East West Rail Phase 2

Stage 2 Road safety audit response report

Offline Highways Passing Places – Package 2 – Oxfordshire (A3 Marsh Gibbon – Compound Access)

Document Number: 133735_RW-EWR-XX-XX-RP-CH-000049

Drawing Number  
133735\_2A-EWR-OXD-A3\_P\_9-DR-CH-010001

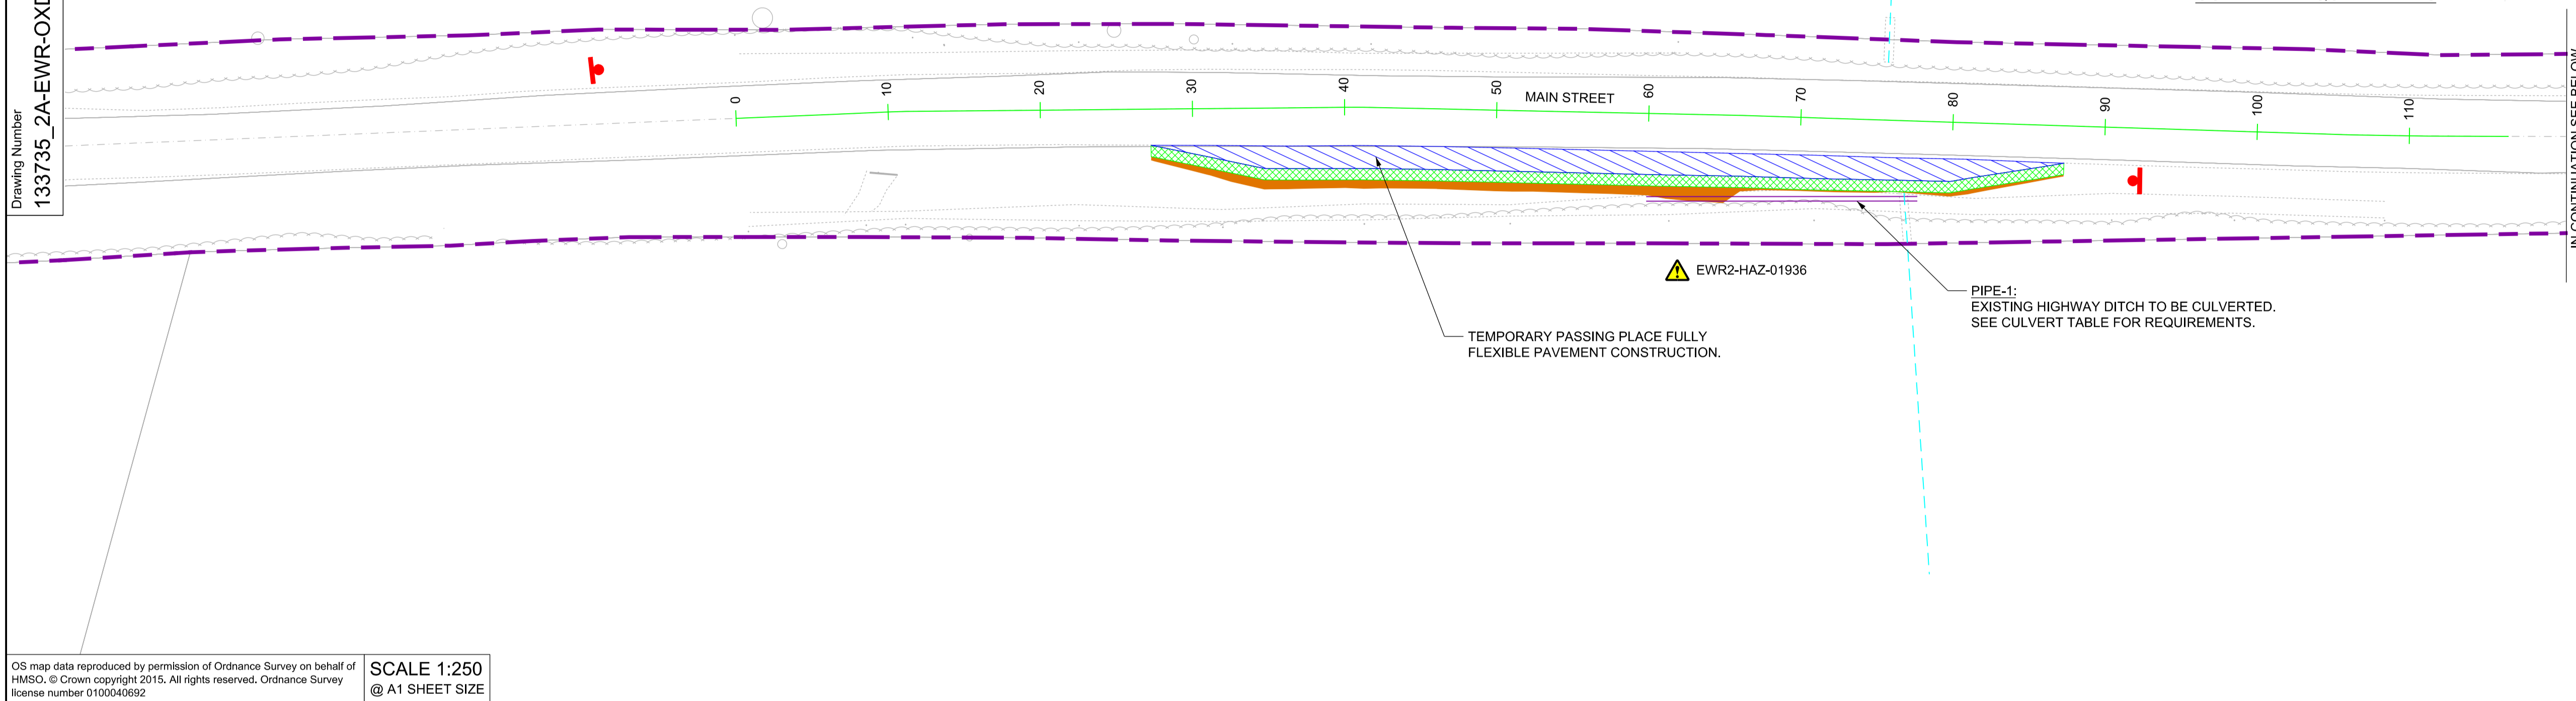
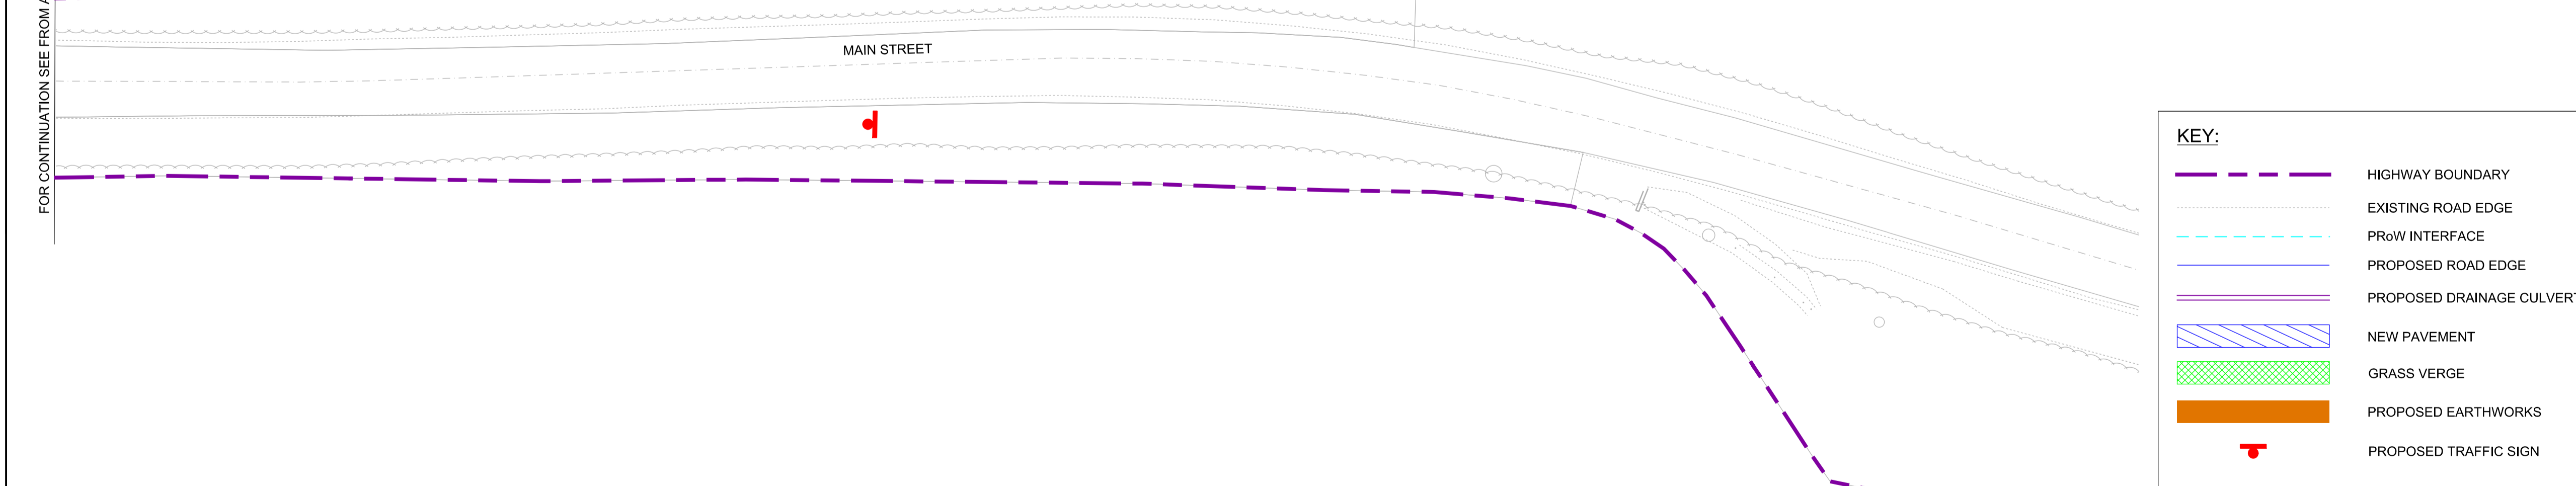
A3-P-9, Unnamed Road (towards Mill Road) – Move passing place A3-P-9 further downstream heading westbound towards passing place A3-P-8. Provide traffic signing to warn pedestrians and construction vehicles of the passing place and presence of pedestrians, respectively. Trim back vegetation around the access to maximise visibility between pedestrians and drivers.

<p>A3-P-9, Unnamed Road (towards Mill Road) – Move passing place A3-P-9 further downstream heading westbound towards passing place A3-P-8. Provide traffic signing to warn pedestrians and construction vehicles of the passing place and presence of pedestrians, respectively. Trim back vegetation around the access to maximise visibility between pedestrians and drivers.</p>	<p>Accept the RSA problem raised but suggest an alternative solution.</p> <p>Passing place to remain in proposed position in accordance with TWAO. Traffic signing to warn vehicles of the presence of pedestrians in advance of the public right of way interface shall be provided, on the eastbound approach and before A3-P-9 and on the westbound approach and before A3-P-9. The site clearance drawings shall include vegetation clearance around the public right of way interface to maximise visibility for pedestrians and drivers. The RSA recommendations with respect to warning signage for pedestrians accessing the carriageway from a public right of way will be shared with the logistics team for inclusion.</p>	Accepted	Proceed as Design Team Response

Drawing Title
**PASSING PLACE A2_P_8
EXISTING UTILITIES AND
SITE CLEARANCE**

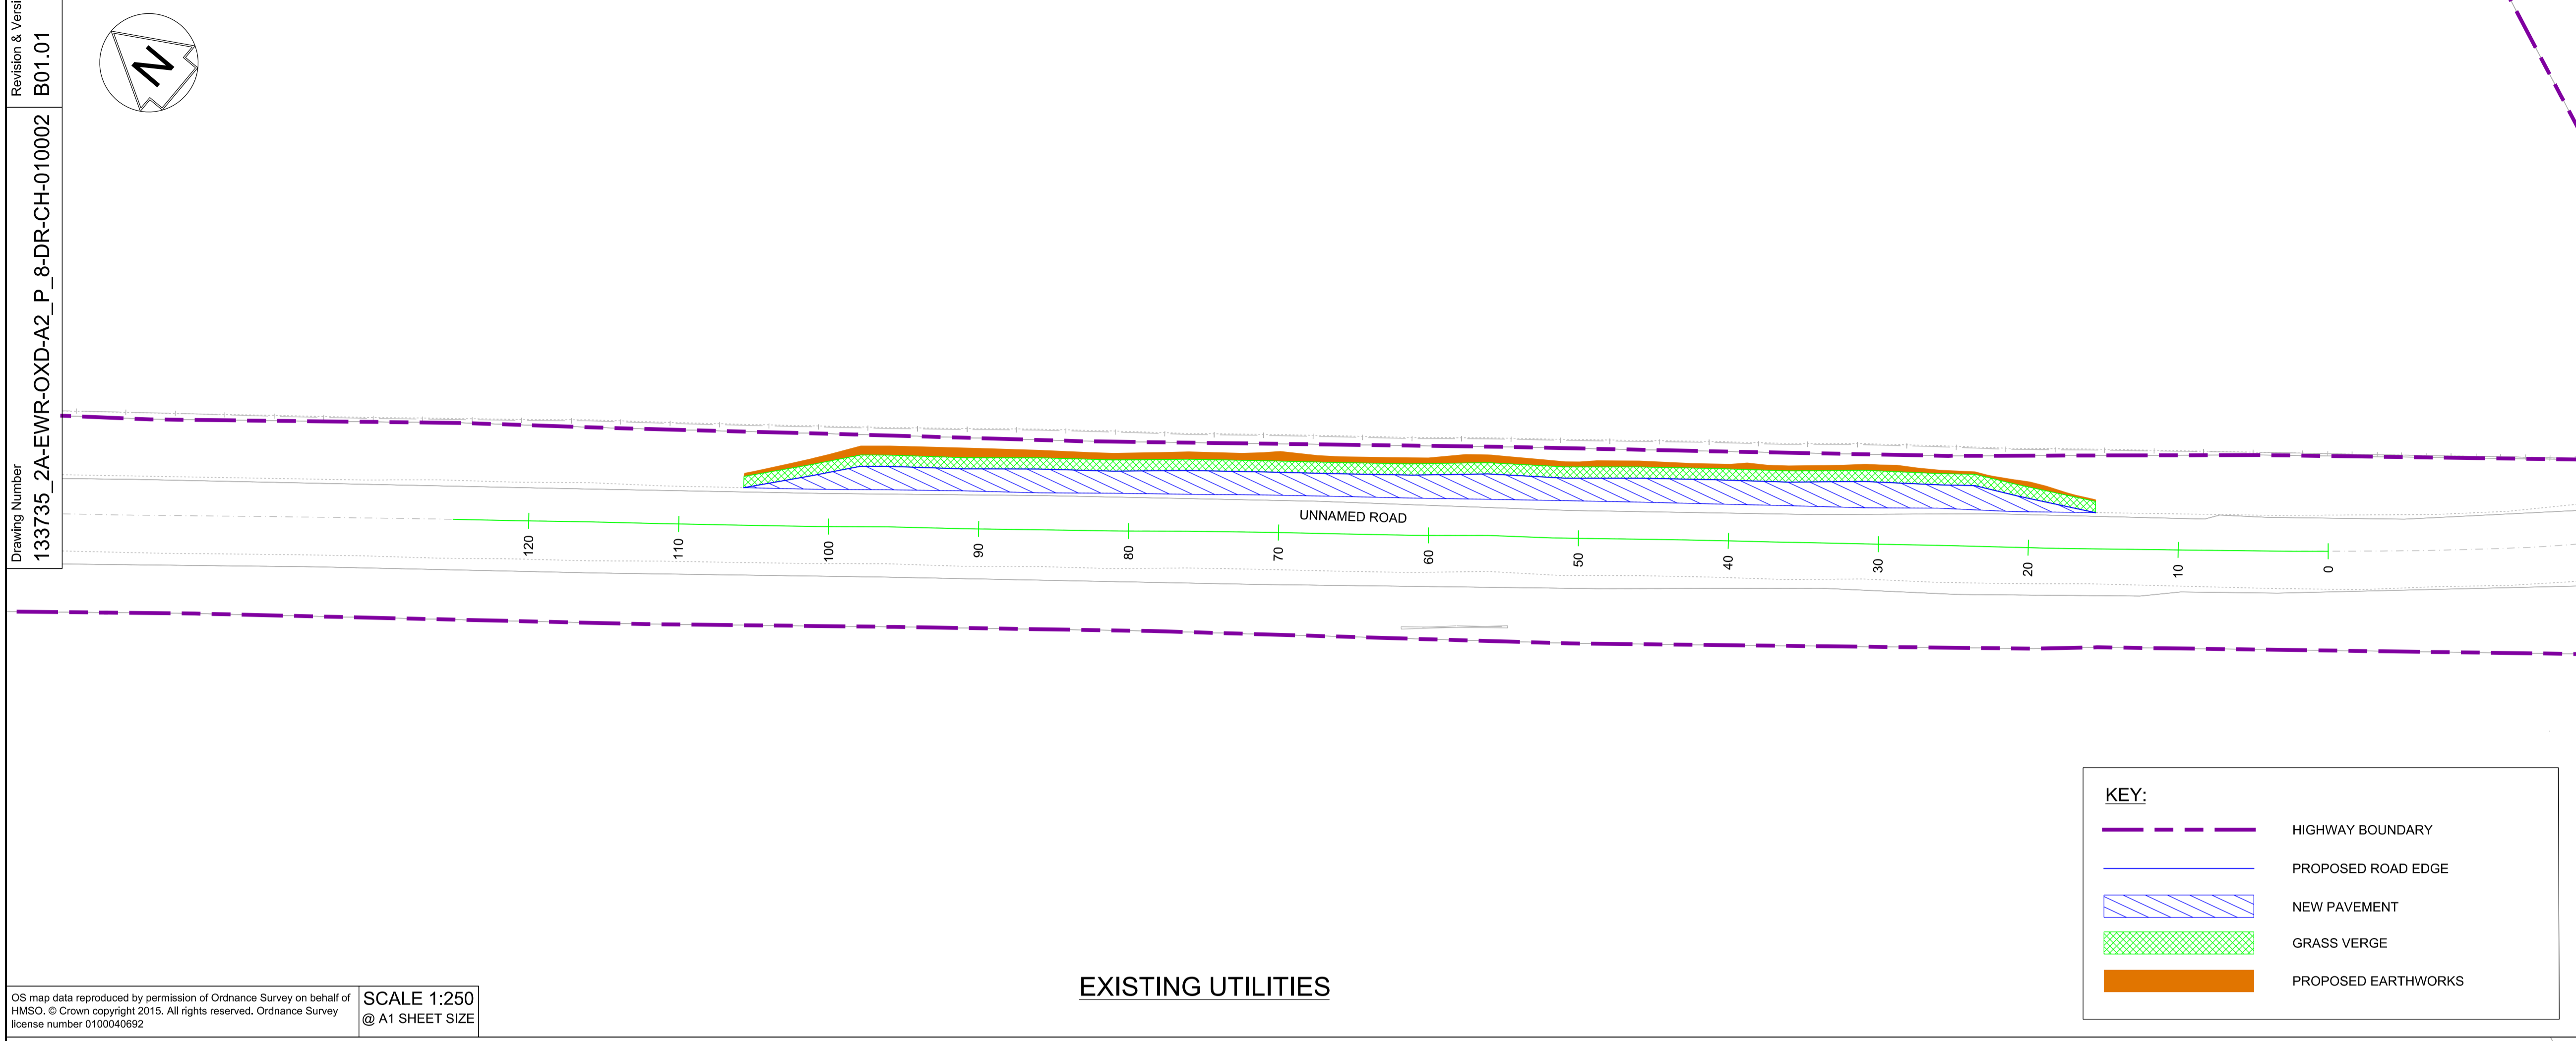
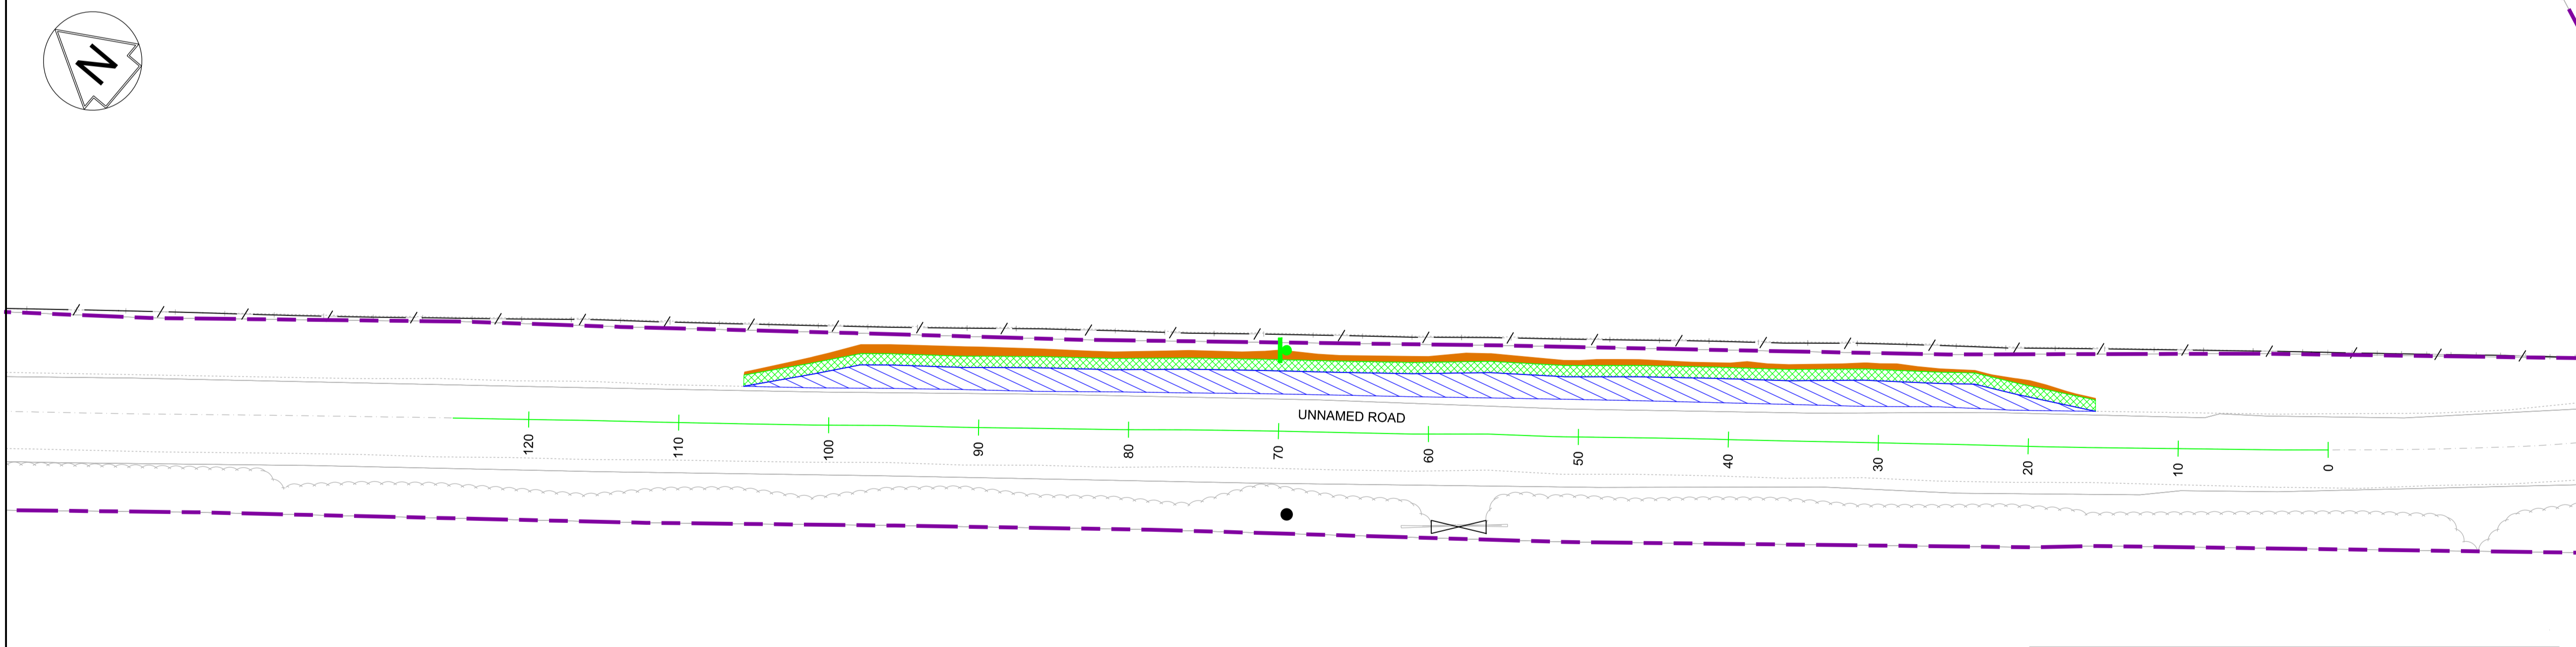
Location: Passing Place A2-P-8.
Unnamed Road (towards Mill Road).

Summary: Disused signpost increases potential severity of collision

There is a disused signpost in the nearside verge heading westbound on Unnamed Road (towards Mill Road), opposite the proposed passing place A2-P-8, which presents an unnecessary hazard to a vehicle, should a collision occur at this location. The likelihood of a vehicle striking the disused signpost is increased by the location of the passing place opposite as vehicles may pass closer to the verge to avoid construction traffic. This disused signpost may therefore lead to an increase in the collision severity should one occur.

Remove disused signpost.

2.2	Passing Place A2-P-8. Unnamed Road (towards Mill Road).	Disused signpost increases potential severity of collision There is a disused signpost in the nearside verge heading westbound on Unnamed Road (towards Mill Road), opposite the proposed passing place A2-P-8, which presents an unnecessary hazard to a vehicle, should a collision occur at this location. The likelihood of a vehicle striking the disused signpost is increased by the location of the passing place opposite as vehicles may pass closer to the verge to avoid construction traffic. This disused signpost may therefore lead to an increase in the collision severity should one occur.	Remove disused signpost.	Accept the RSA problem and recommendation made by the RSA team. The disused signpost is included for removal in the Site Clearance Drawing.	Accepted	Proceed as Design Team Response
